**WELWYN HATFIELD BOROUGH COUNCIL – DEVELOPMENT MANAGEMENT**  
**DELEGATED REPORT**

**APPLICATION No:** S6/2015/1026/FP

**SITE ADDRESS:** 95 Bramble Road Hatfield AL10 9SB

**DESCRIPTION OF DEVELOPMENT:** Erection of a front porch and two storey side extension and ground floor rear extension

dwg title: Proposed Floor Plans and Elevations

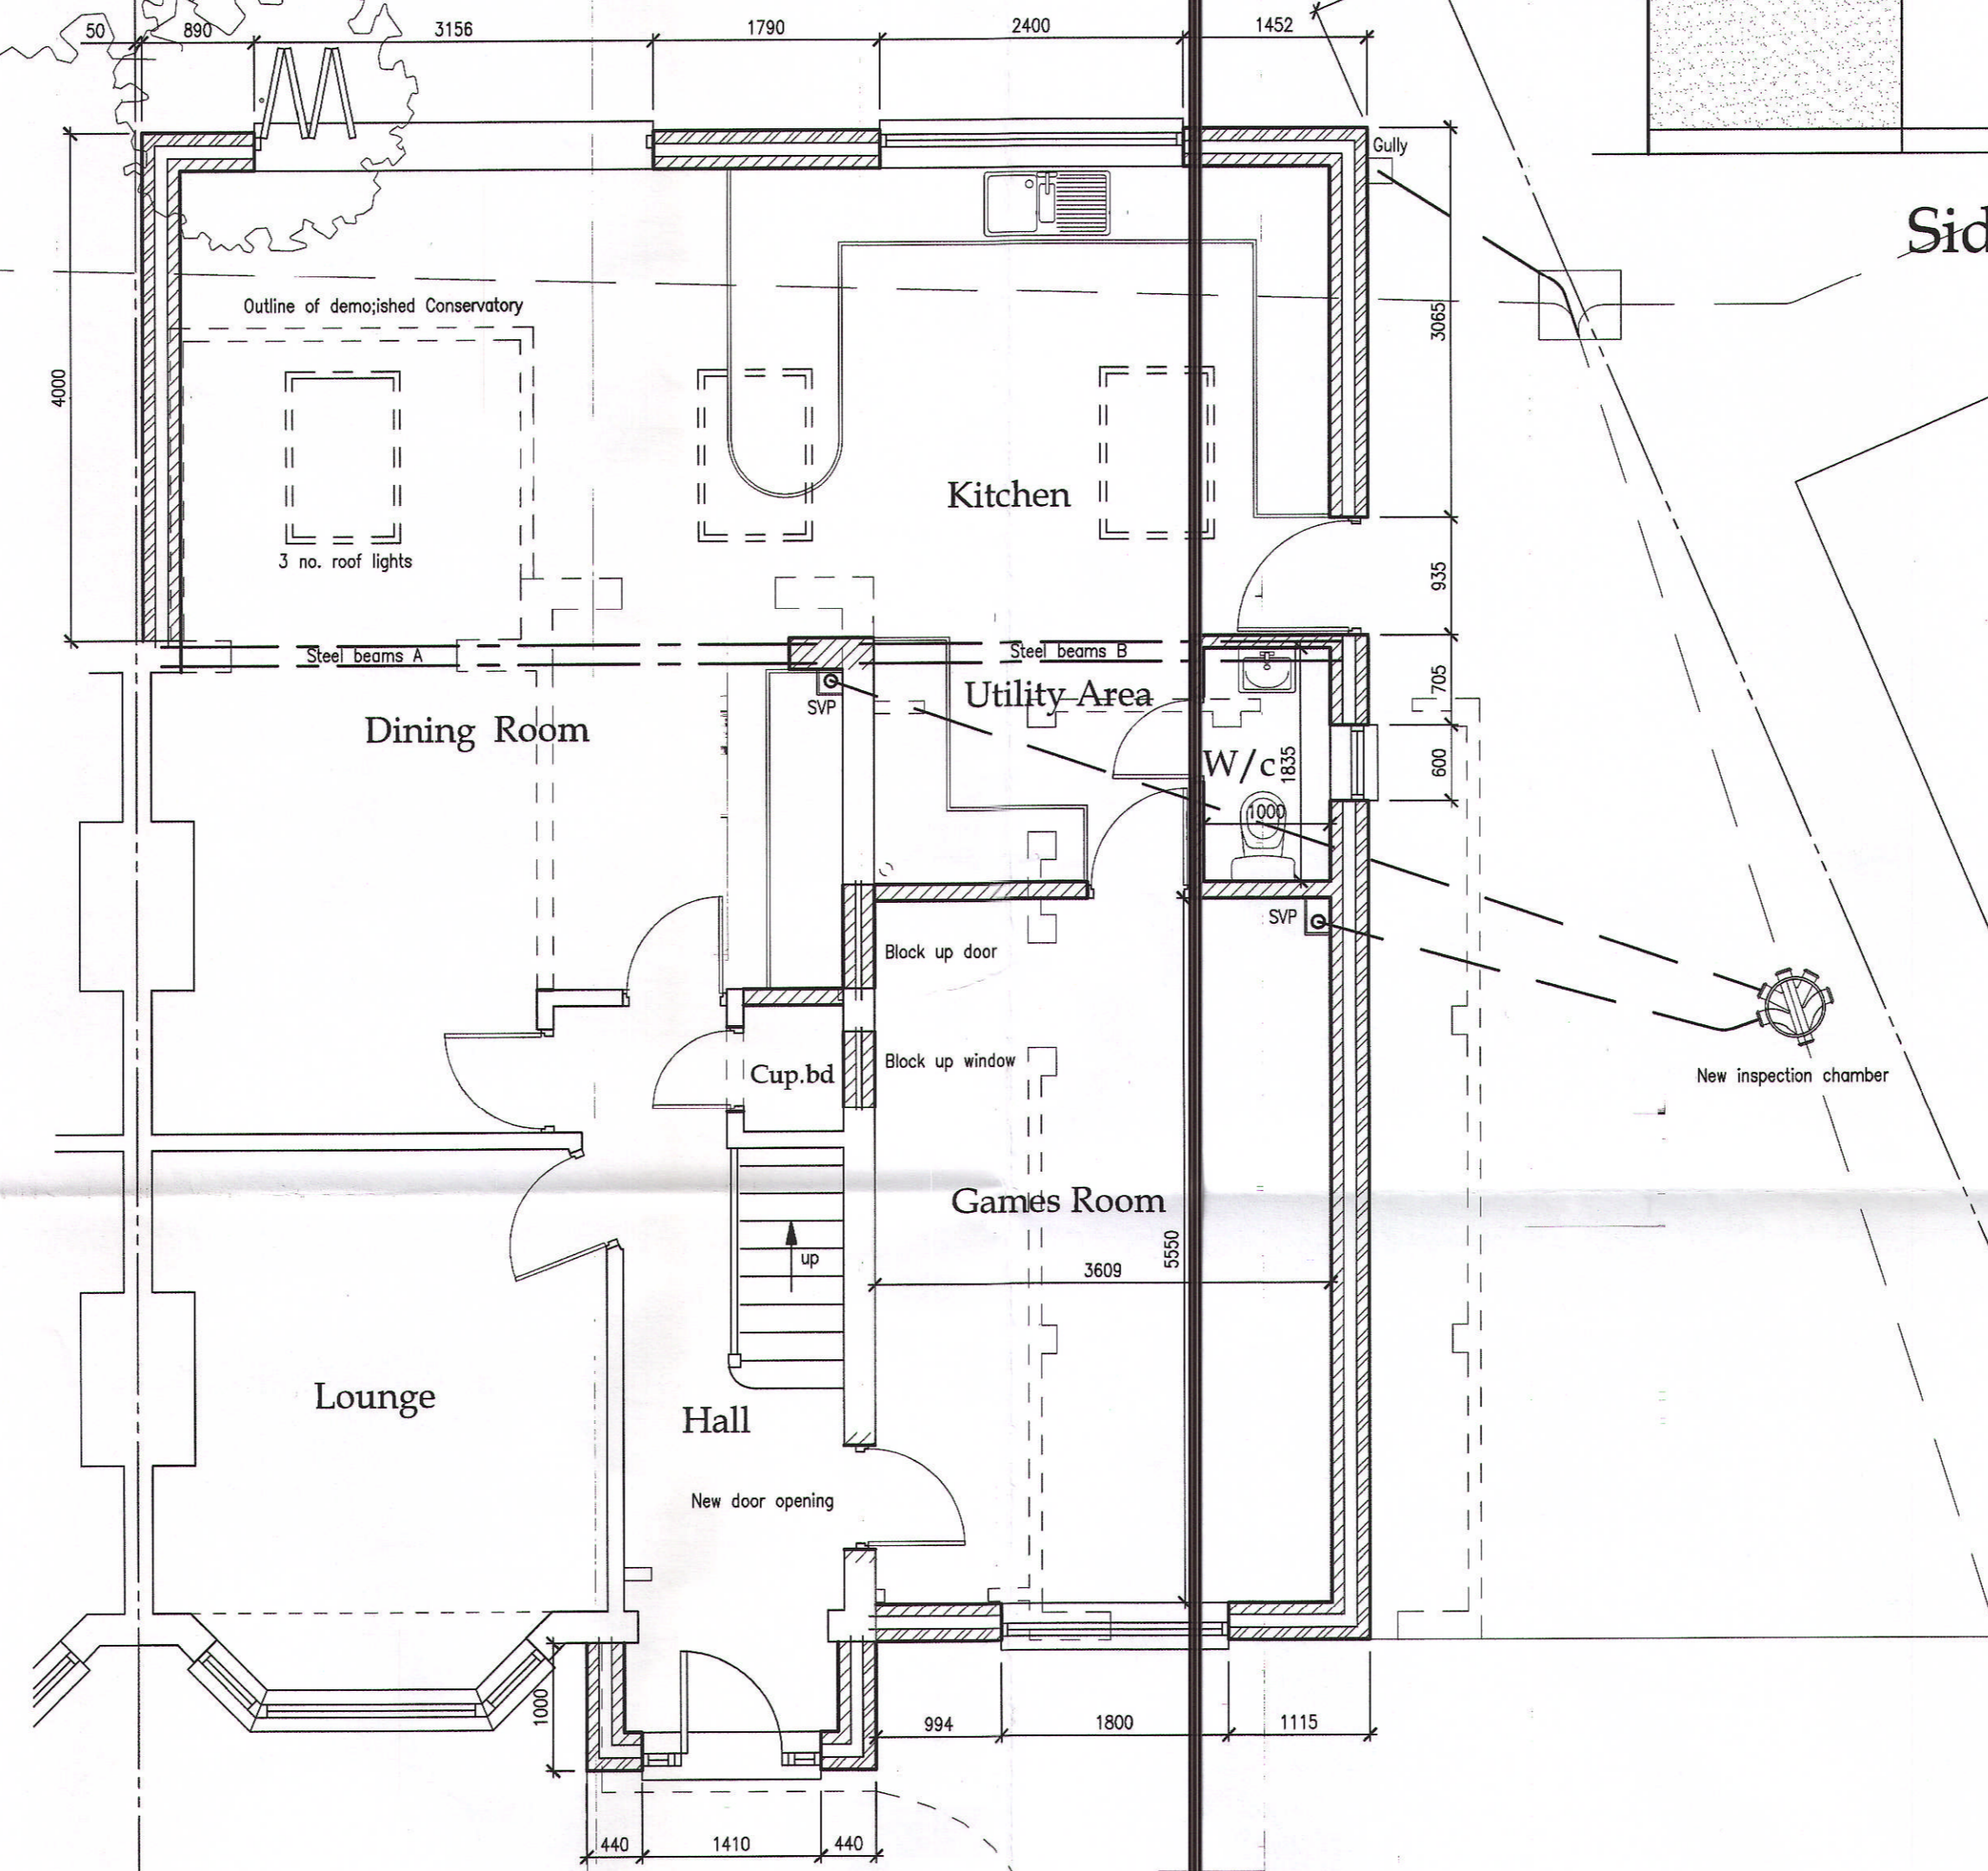
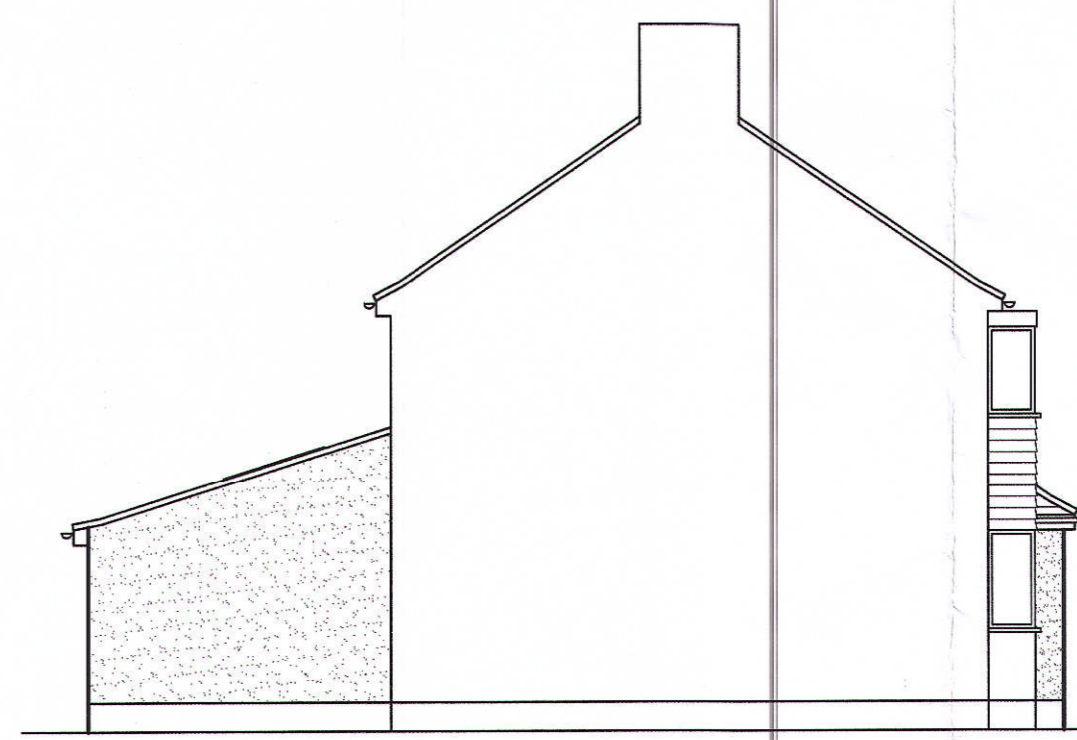
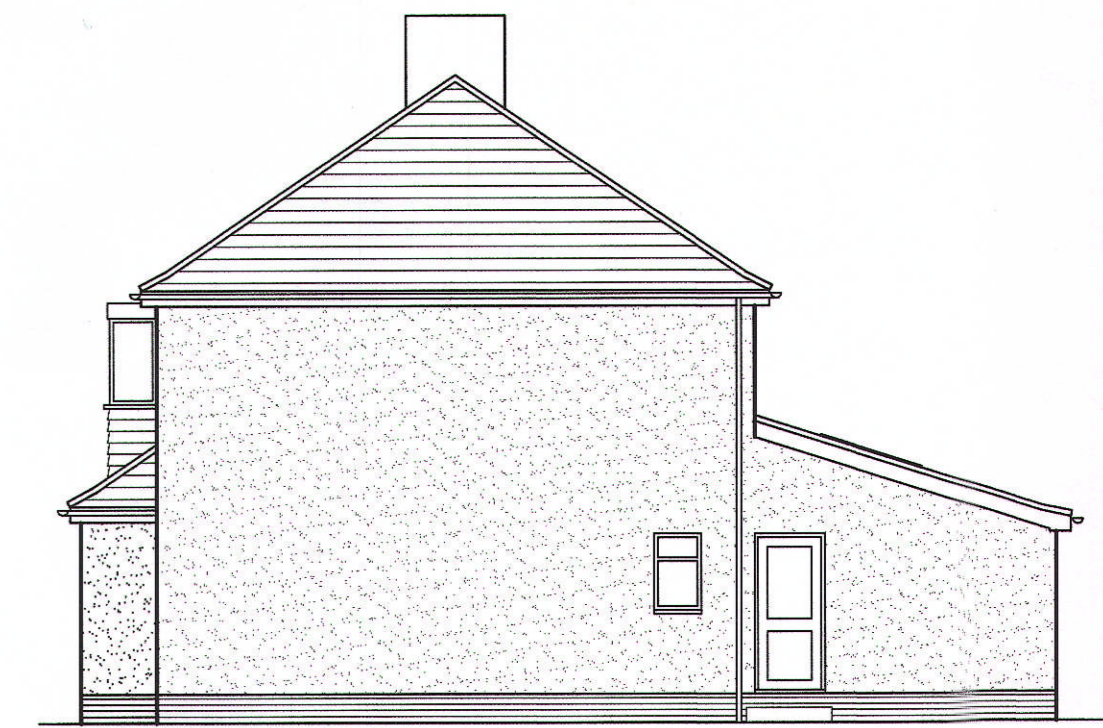
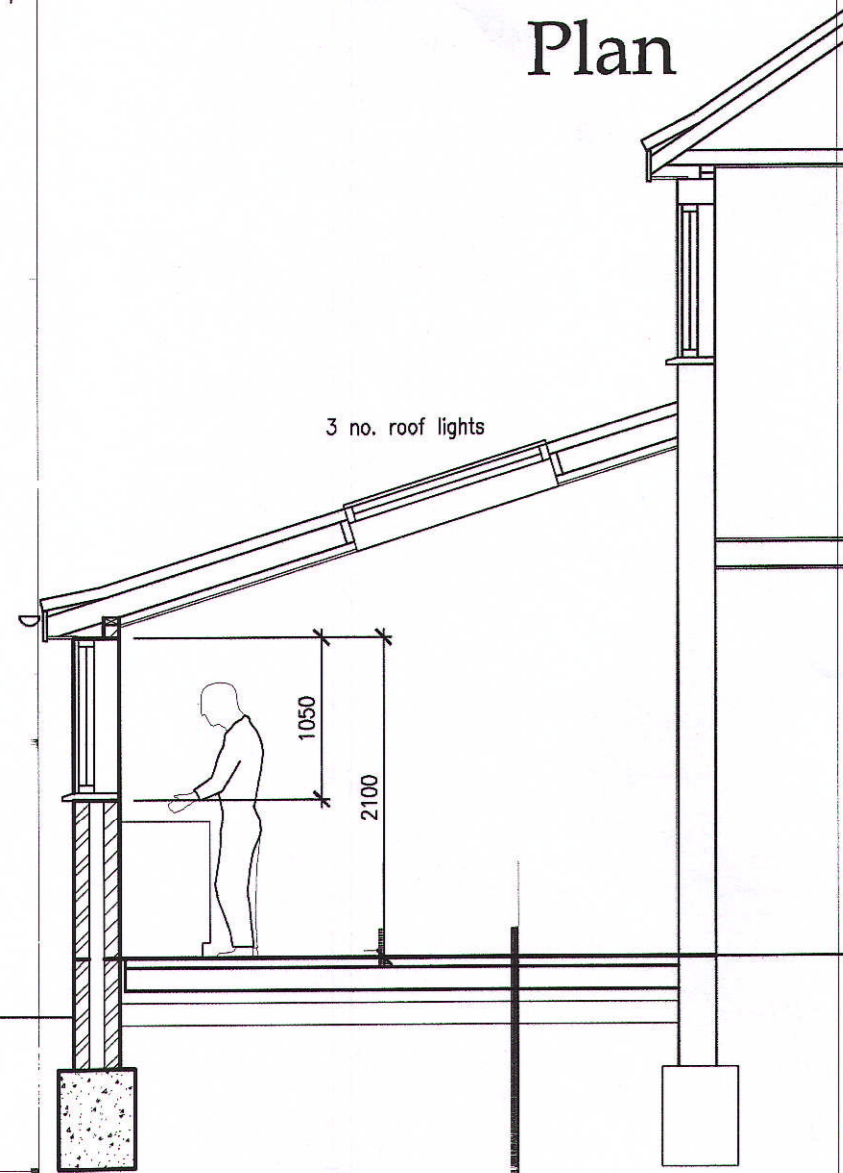
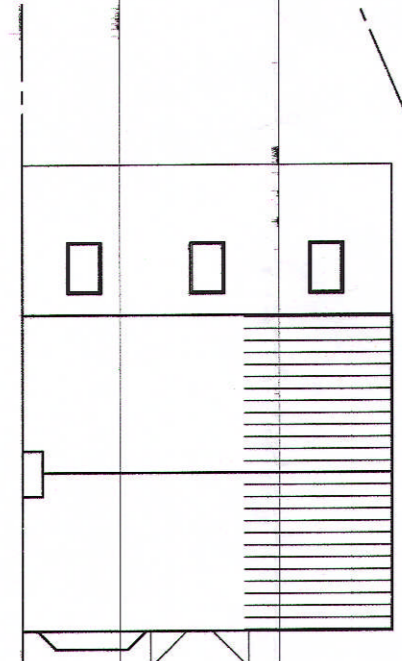
The proposed first floor side addition sits flush with the front and rear wall of the original dwelling and presents a hipped roof with matching ridge and eaves height. As a result of the matching height and flush alignment to the host dwelling, the first floor addition cannot be considered subordinate to the host dwelling. The design of the first floor side extension is reflective of the host dwelling and surrounding area in terms of its roof type, construction and finishing materials as well as the design, location and size of fenestration detailing.

Within the SDG it is stated that “the spacing of buildings adjacent to and in the locality of the site should be reflected”. When discussing multi-storey side extensions this point is re-iterated in that “it is important that existing spacing in the street scene is reflected which may result in larger distances ... (than the 1m suggested) ... being required. The plot of the site is unique within the street scene, giving enough width to extend to the extent of the single storey garage without coming within the expected 1m spacing at first floor level between the development and the flank boundary. However, this extension would not reflect the spacing required within other existing multi-storey side extensions within the street scene and more importantly, those that may be proposed/required in properties within the street scene in the future. As a result, I recommend that in this case, a distance further than 1m between the extension and the flank boundary would be required for the proposal to be considered reflective of the design and character of the street scene.

Accordingly, it is considered that the first floor side extension is insufficiently designed and would result in an overly dominant addition which would be spaced in a fashion which would not reflect the spacing in the street scene.

When considered as a whole, the proposal fails to comply with Policies D1 and D2 of the Welwyn Hatfield District Plan 2005, the Supplementary Design Guidance Statement of Council Policy 2005 and the National Planning Policy Framework in terms design. The reasons for the failure to comply with said policies could be summarised as the over-dominant nature of the first floor side extension which would fail to reflect the existing spacing within the street scene.
